Our ref: NO/2021/113494/01-L02
Your ref: 3/2021/0242
Date: 07 May 2021

**OUTLINE APPLICATION FOR UP TO 2 TWO STOREY RESIDENTIAL DWELLINGS
(ACCESS AND LAYOUT DETAILS APPLIED FOR ONLY)
LAND TO REAR OF GLENCROFT, PENDLE AVENUE, CHATBURN, BB7 4AX.**

Drawing Title
 Topographical Survey of Land at:
 Glencroft, Pendle Avenue, Chatburn,
 Clitheroe, Lancashire, BB7 4AX

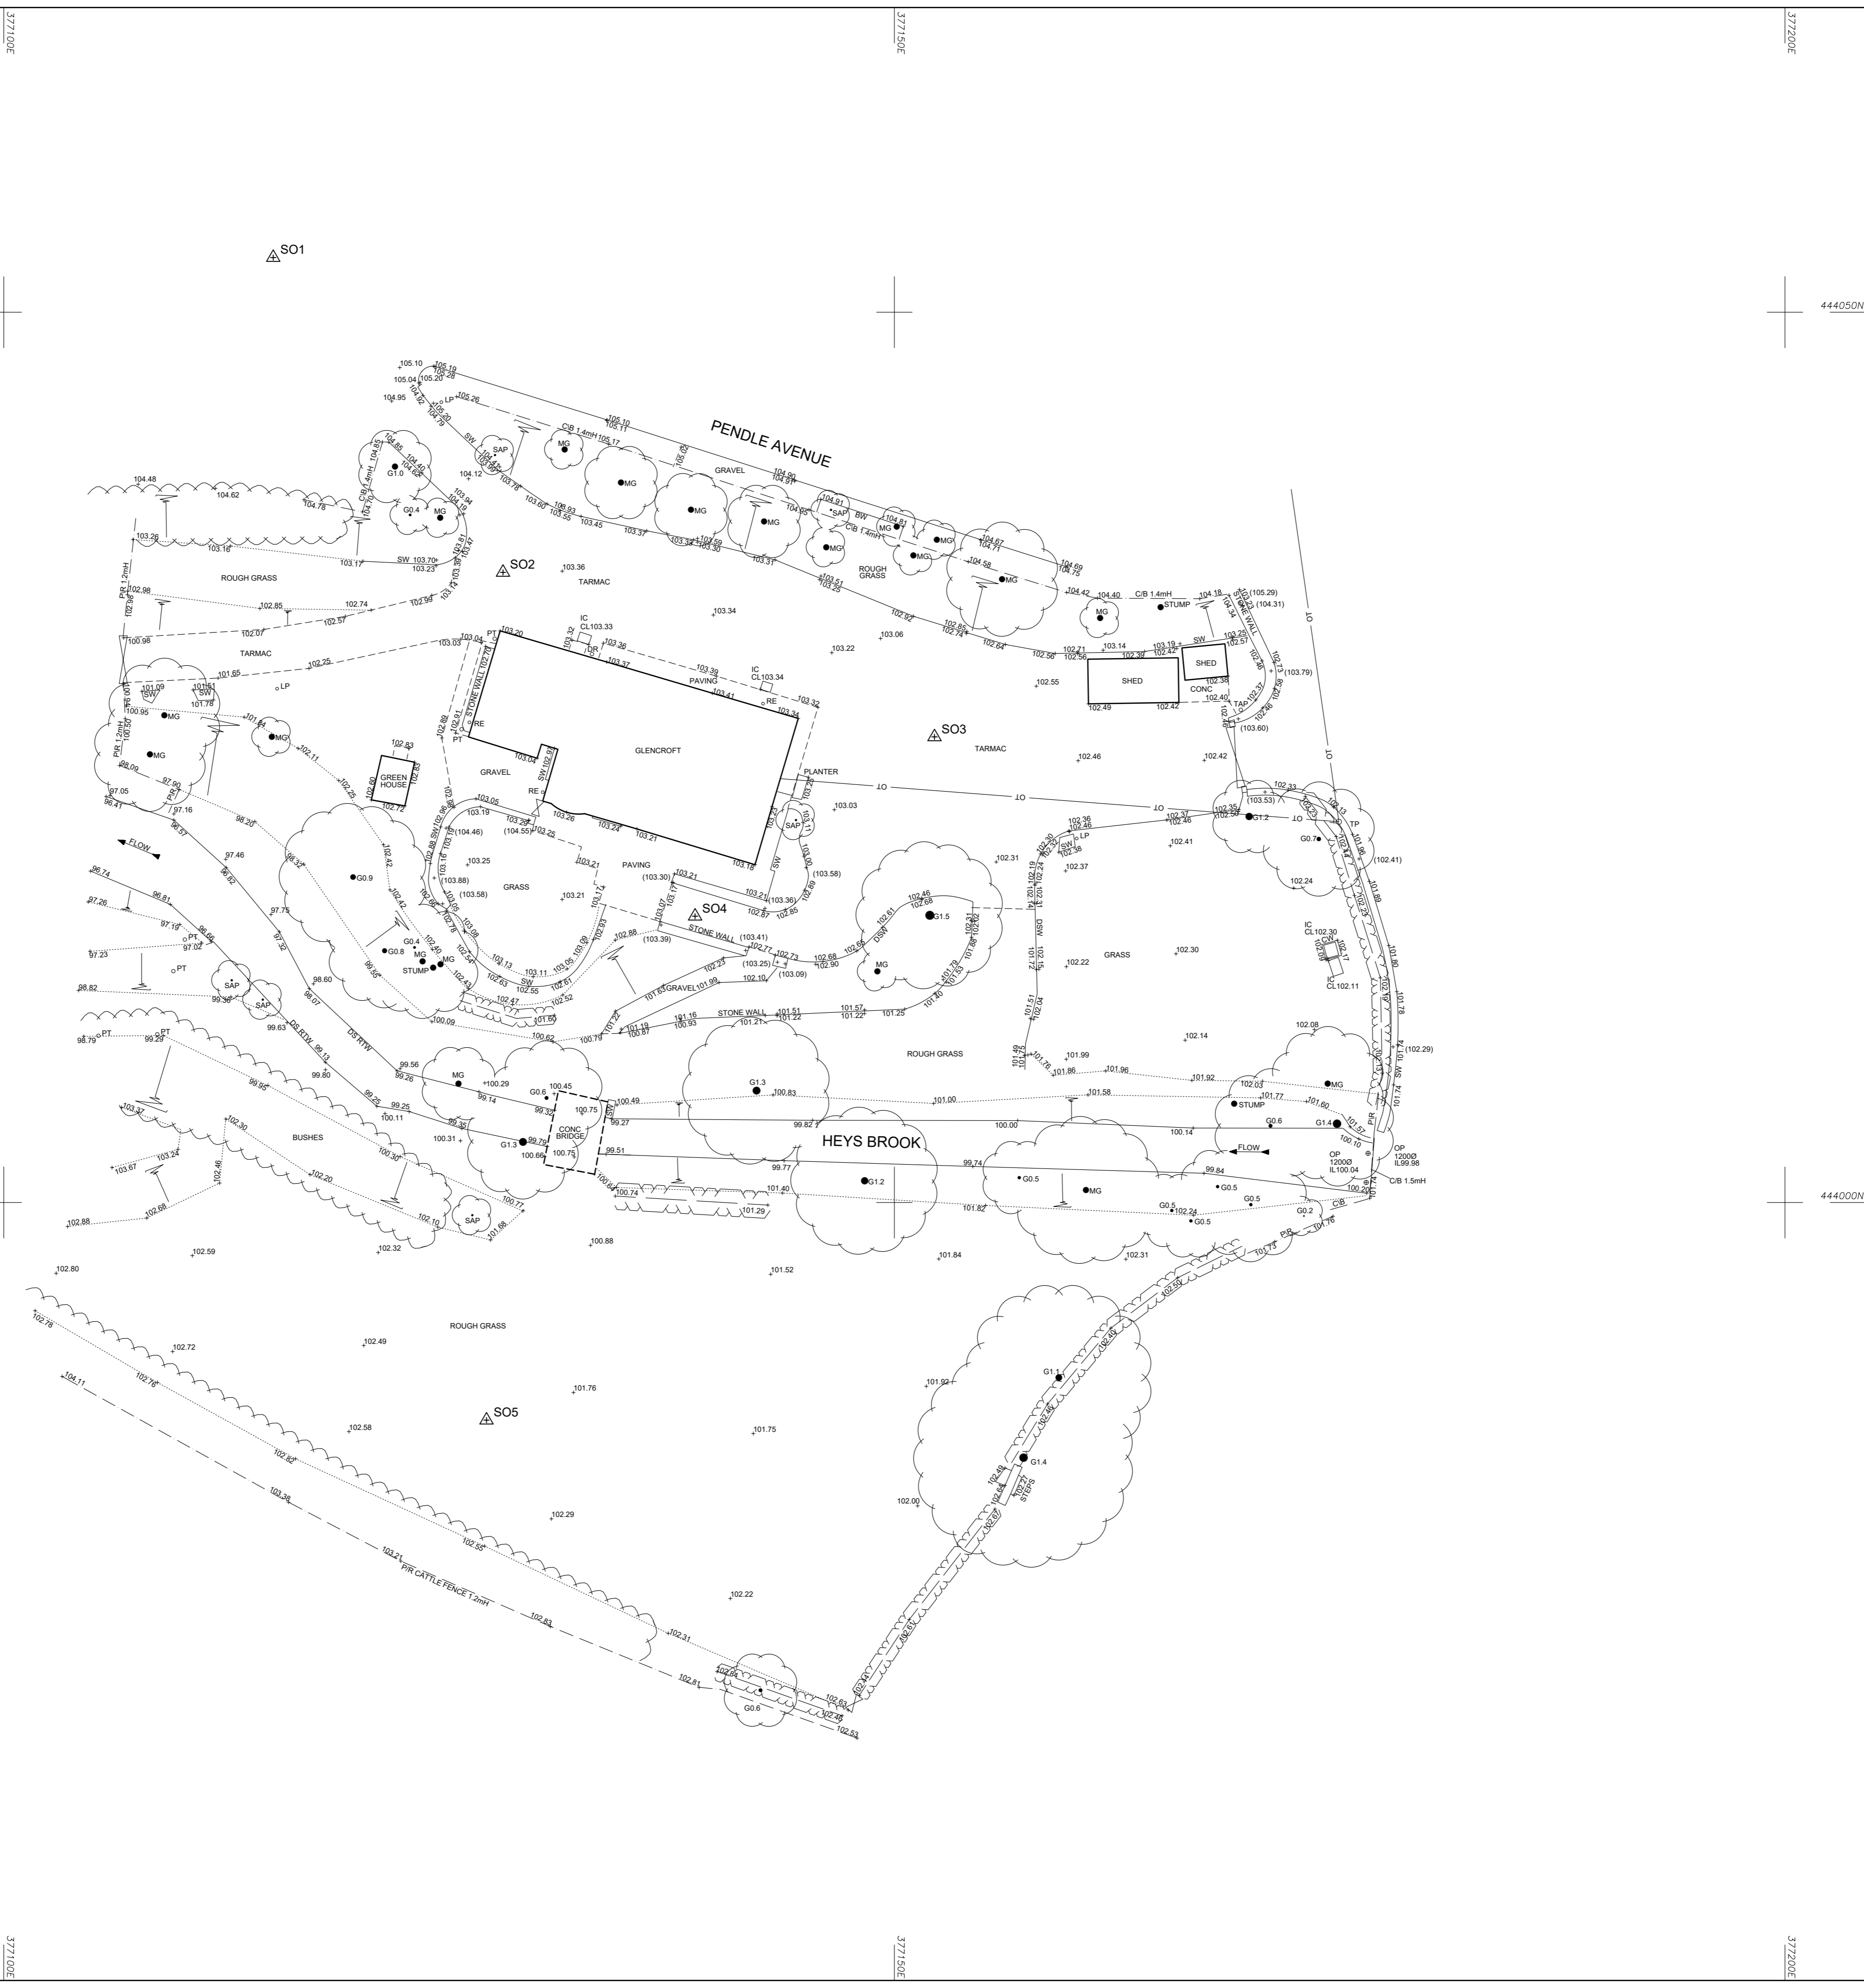
The National Generalised Model extents were provided to the applicant via a data request, however, this is a broad scale model which generally means that local detail has not been accounted for. It is clear from the flood zone line drawn on the topographic survey in Appendix E/figure 5 of the FRA that the flood extents do not follow the topography in this area, which demonstrates that the modelled flood extents at this location are not realistic. However, no further assessment of the extents has been made.
